**KIRKLEES METROPOLITAN COUNCIL
INVESTMENT & REGENERATION SERVICE**

DELEGATED DECISION TO DETERMINE PLANNING APPLICATIONS

Reference No: 2021/62/91309/E

Description: Erection of front dormer and front extension

PROPOSED EXTN

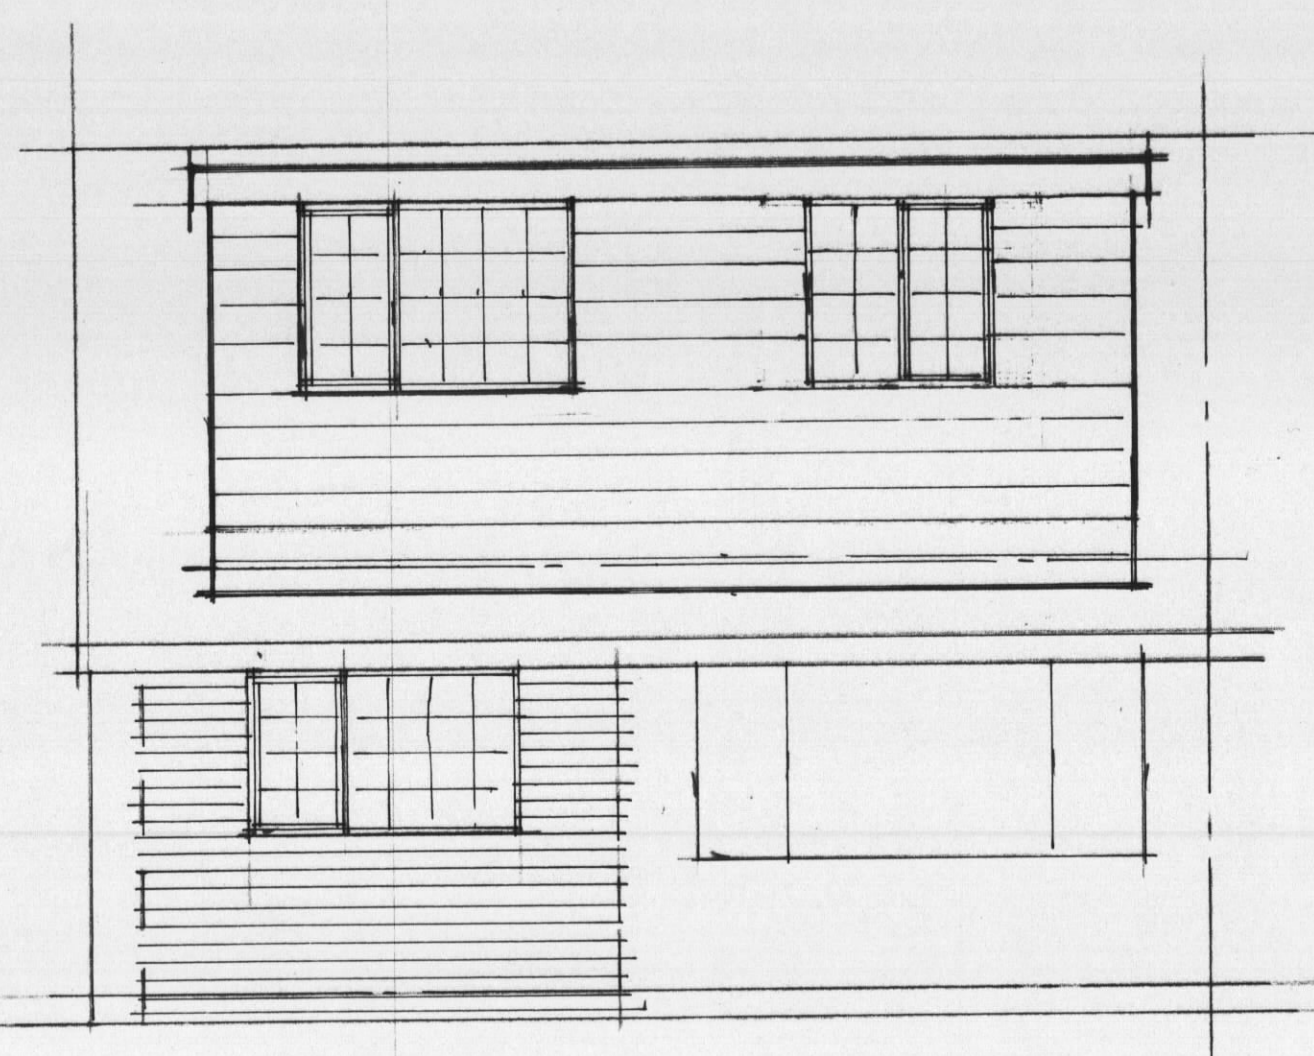
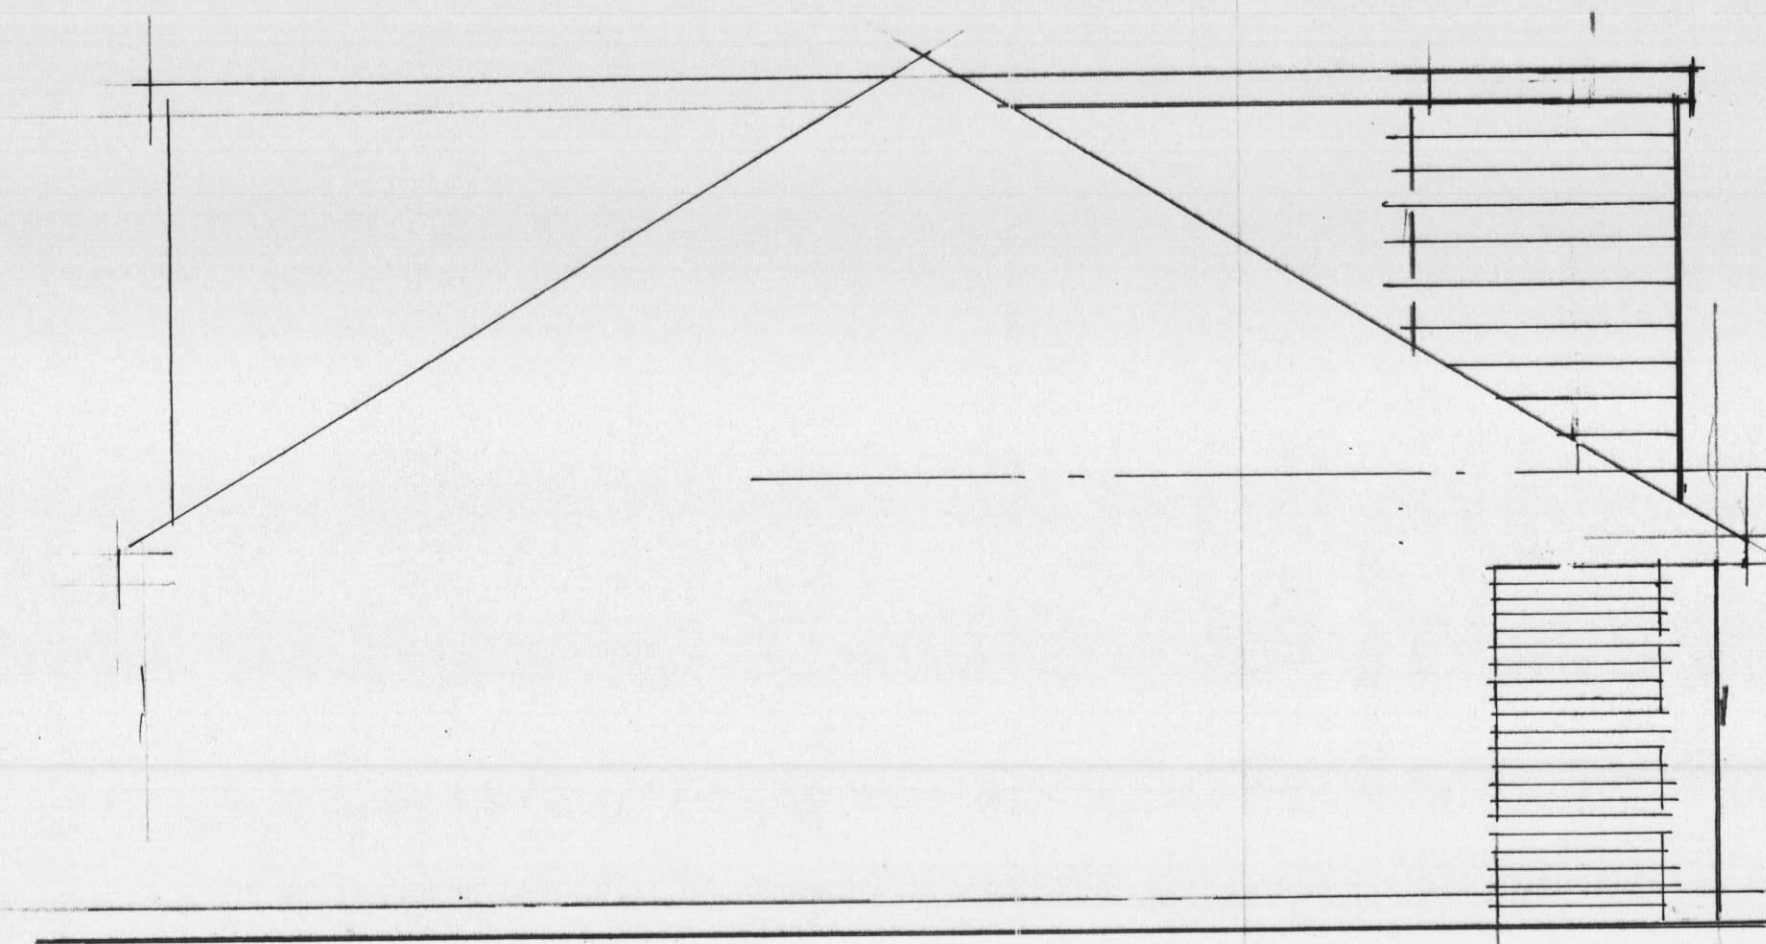
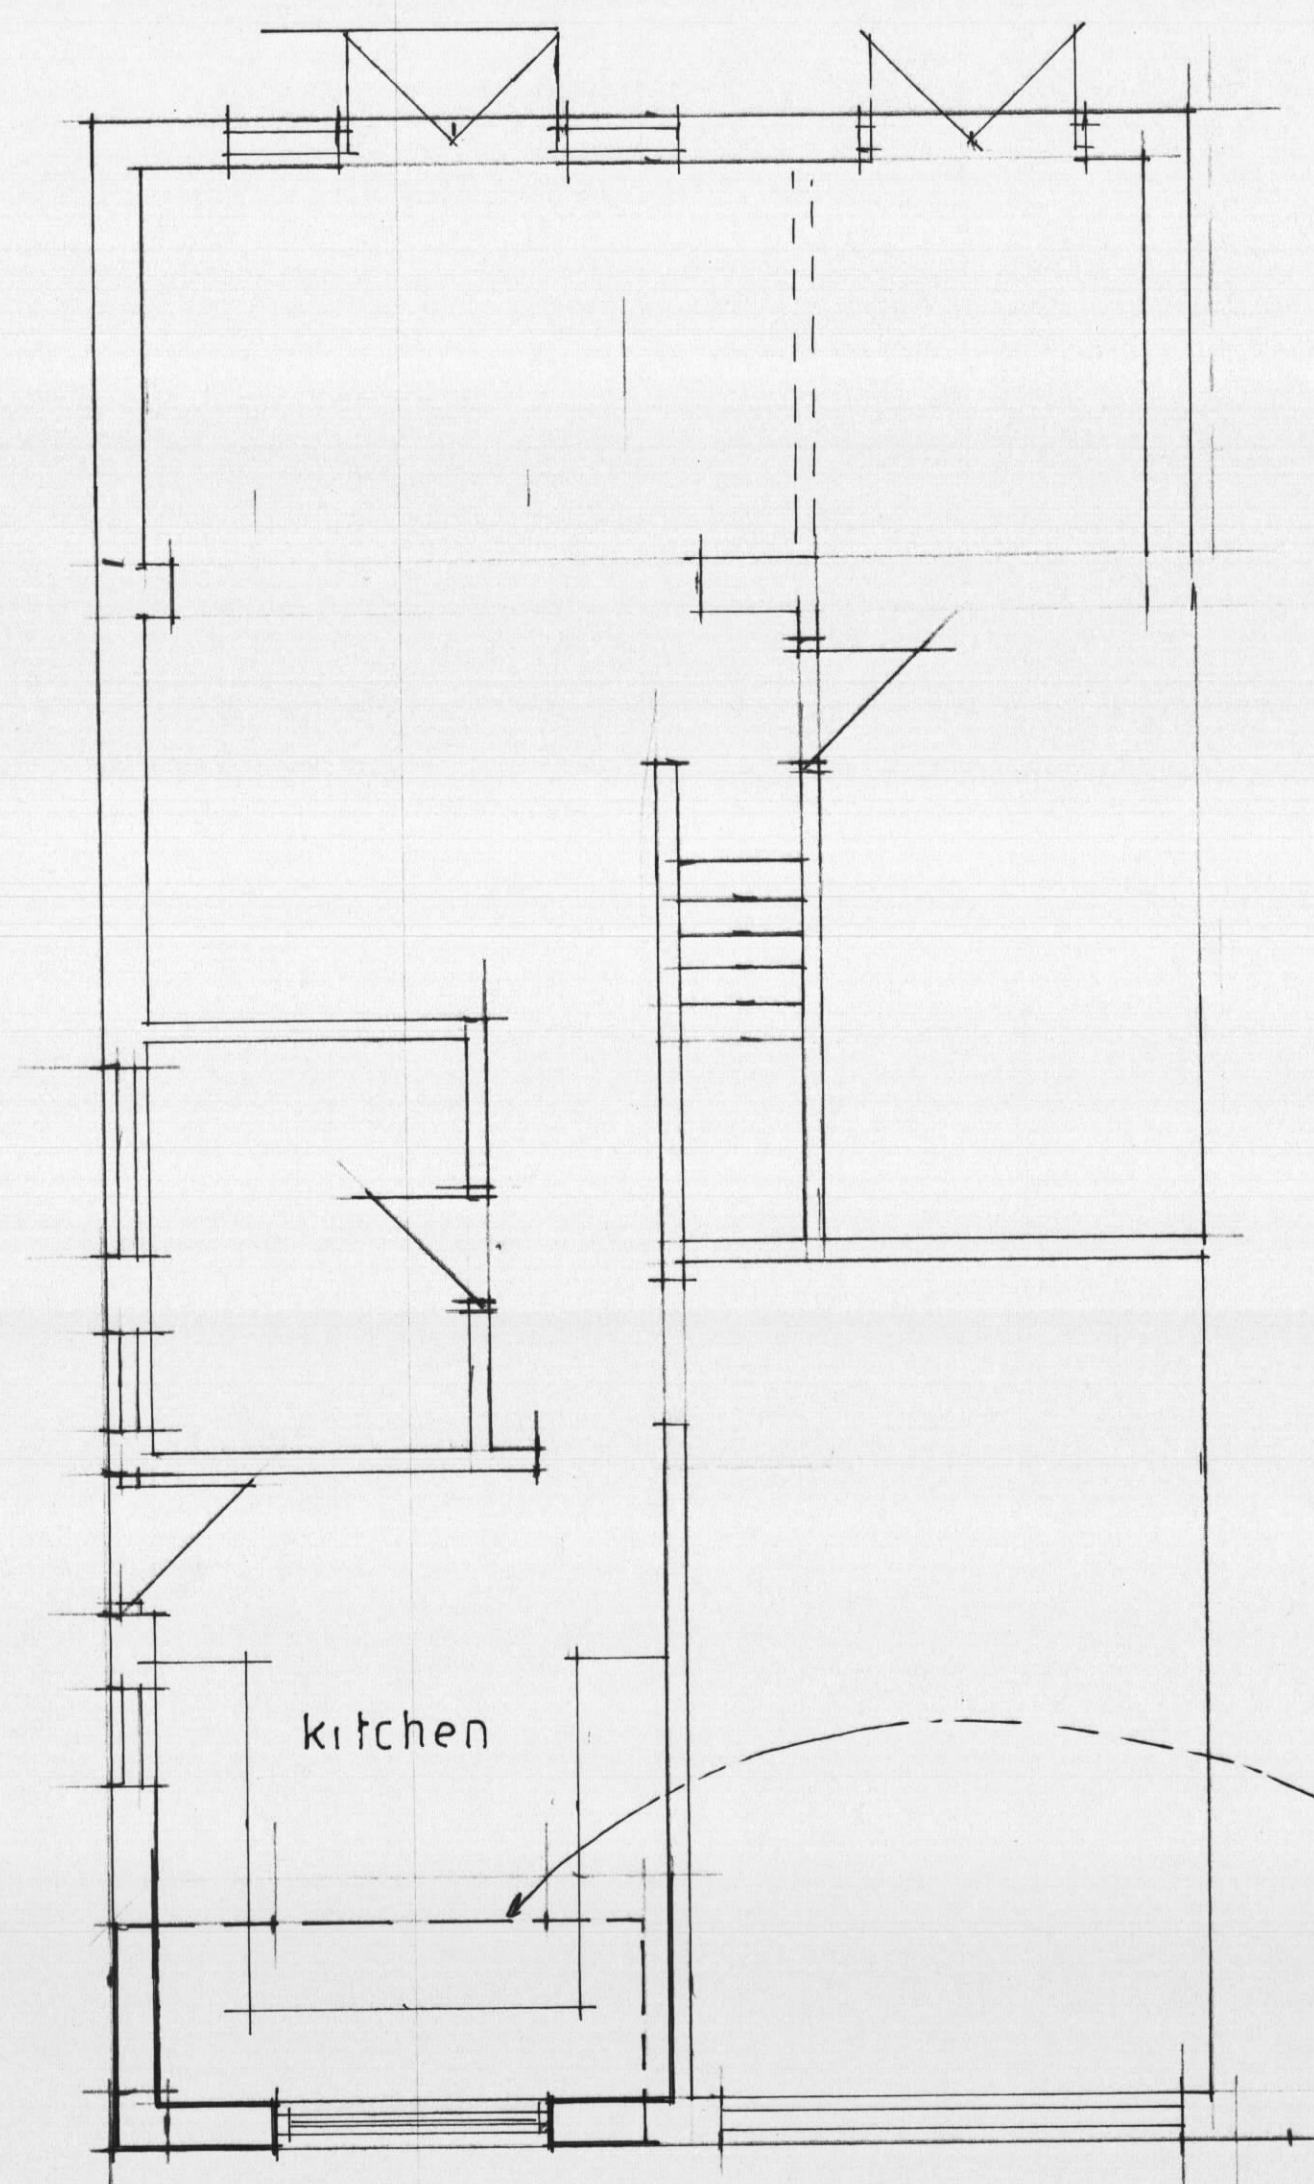
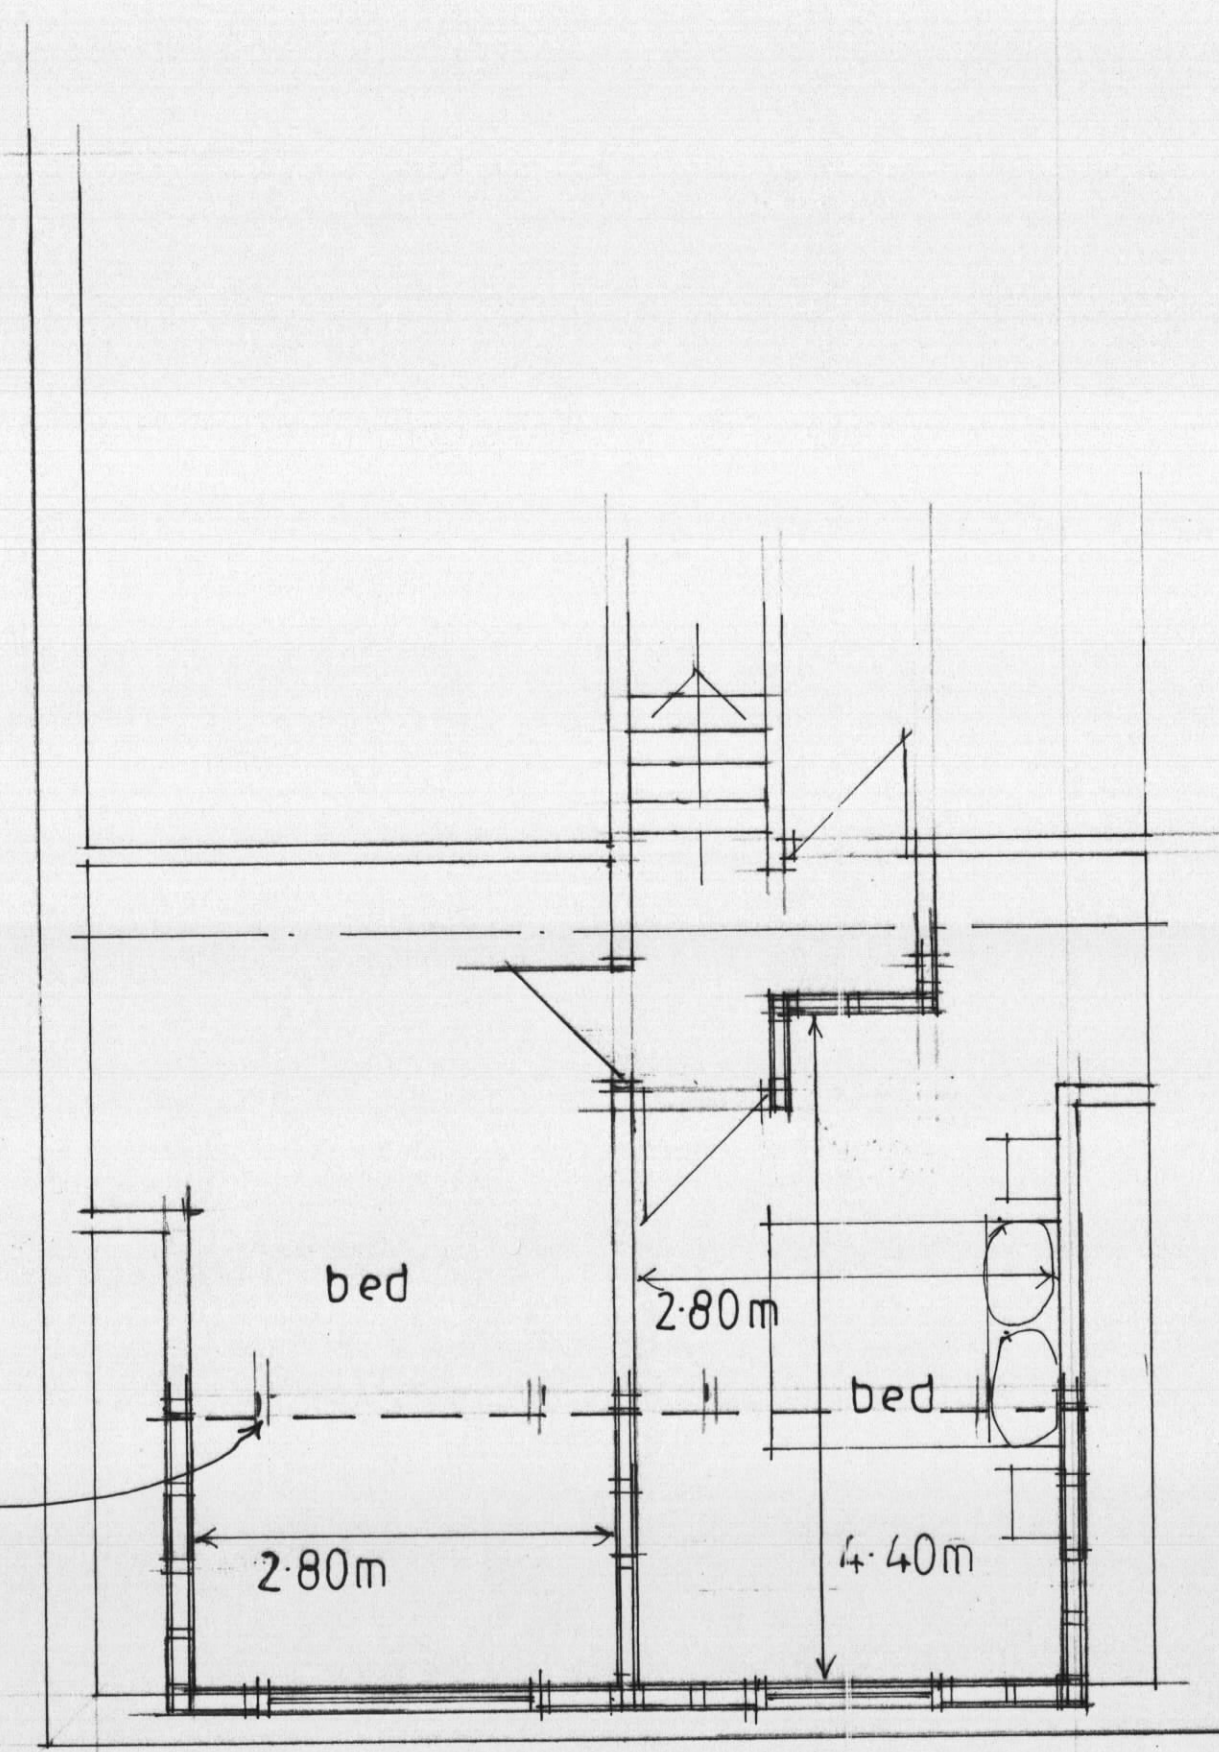
The proposed front dormer would be an extension on the existing front dormer window. The proposed dormer would extend an additional 2 metres out the existing dormer, creating a total projection of 4 metres. It would be 6 metres wide and a total of 2.9 metres deep. It would have two windows in the front elevation and would serve two bedrooms.

The proposed front extension would infill and existing canopy at the front of the dwelling. The proposed would project 1.5 metres to the same projection as the existing principal elevation. It would have a window in the proposed front elevation and would serve an extension to the existing kitchen.

The proposed development would enlarge the existing front dormer. It is noted that multiple properties on the street have had similar design and scale front dormers approved and erected. The proposed would be in keeping with the existing dwelling in terms of design and materials. It is therefore considered that the proposed would not be out of character with the wider street scene or existing dwelling.

The proposed front extension would not project past the existing principal elevation. There is variety in the street scene, and it is considered that the proposed would be more in keeping with the neighbouring properties than the existing. The development would be in keeping with the existing property in terms of design and materials. Therefore, no harm is considered caused to either the existing dwelling or the neighbouring property.

The proposed development would result in the existing windows projecting further towards the front elevation of the dwelling. It is considered that no additional harm would be caused to the neighbouring properties due to the proposed development as the proposed would be at the front of the property and would therefore not face any neighbouring inhabited rooms and the proposed would not amend the existing projection of the front elevation.
